Botley West Solar Farm – EN010147

Representation concerning the Applicant's latest submissions

From Interested Party: Steven Jenkins

\* Proposed Landscape areas are indicative  
 \*\* Areas of grassland beneath /not beneath solar arrays are managed through conservation grazing, and to deliver BNG

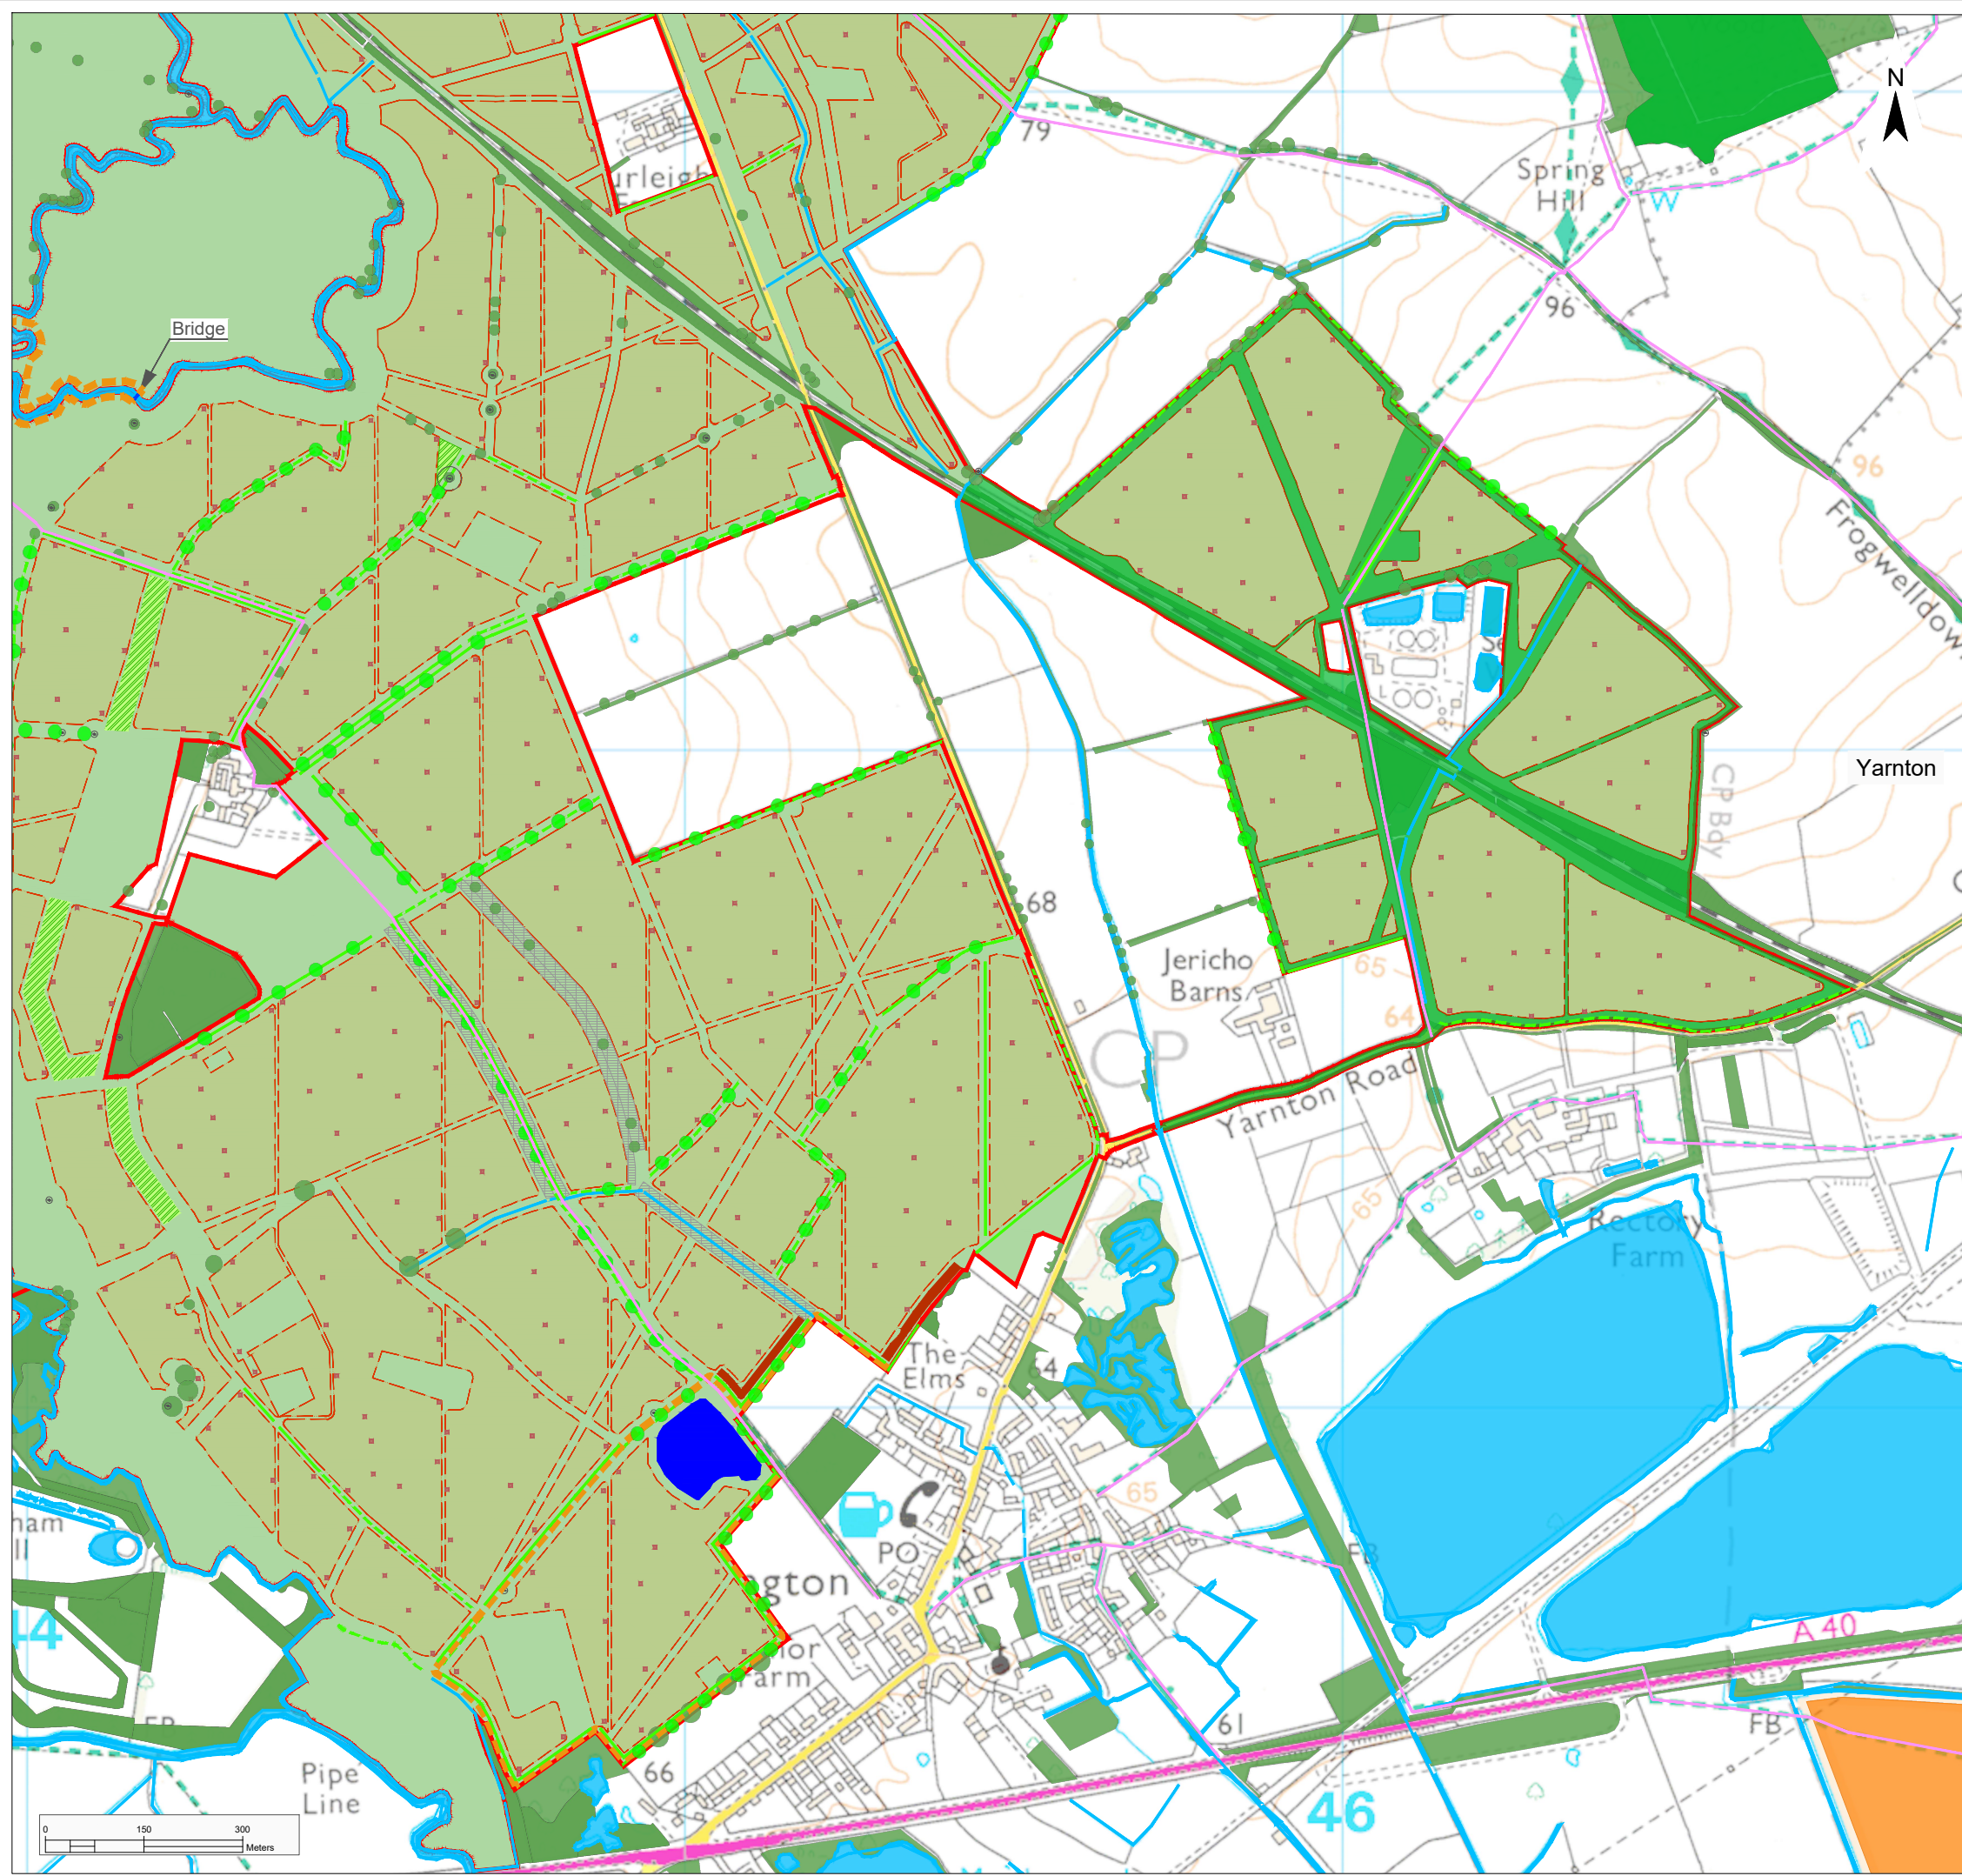
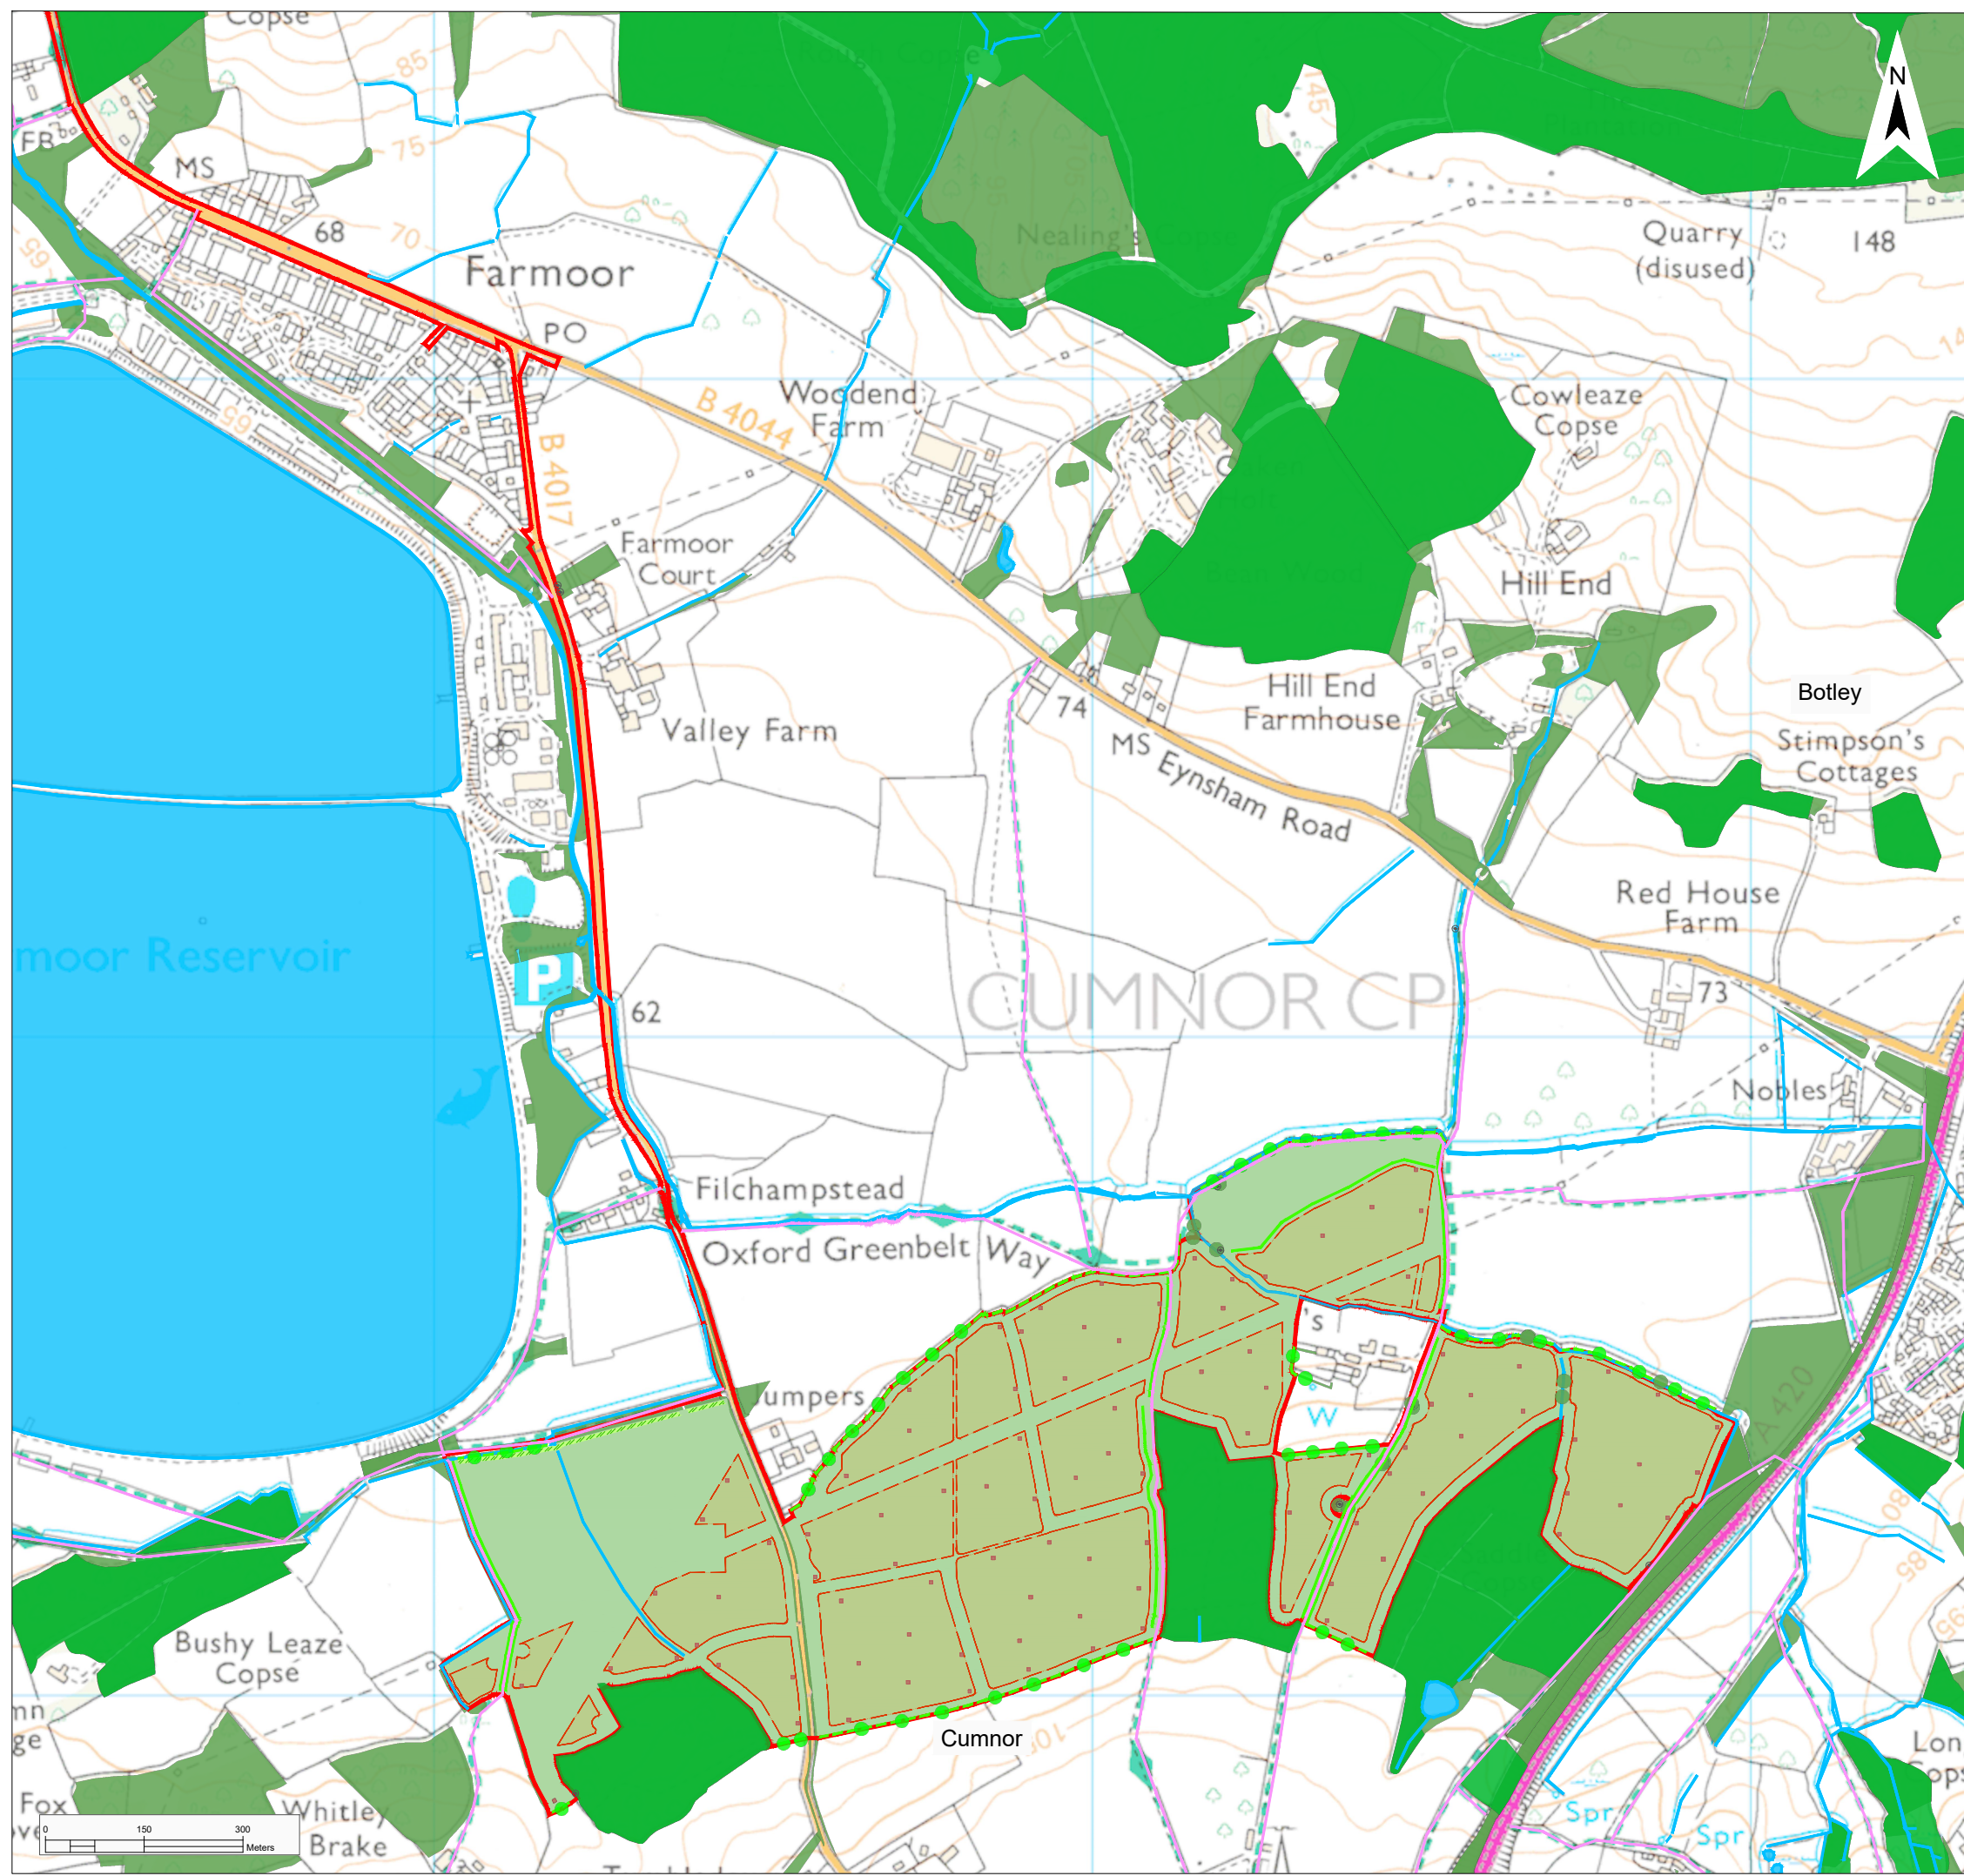
There appears to have been no further satisfactory resolution of the issue of **community food-growing areas**. The areas concerned should be removed from the red-line boundary, as previously raised in REP5-072, REP5-093 and REP6-076.
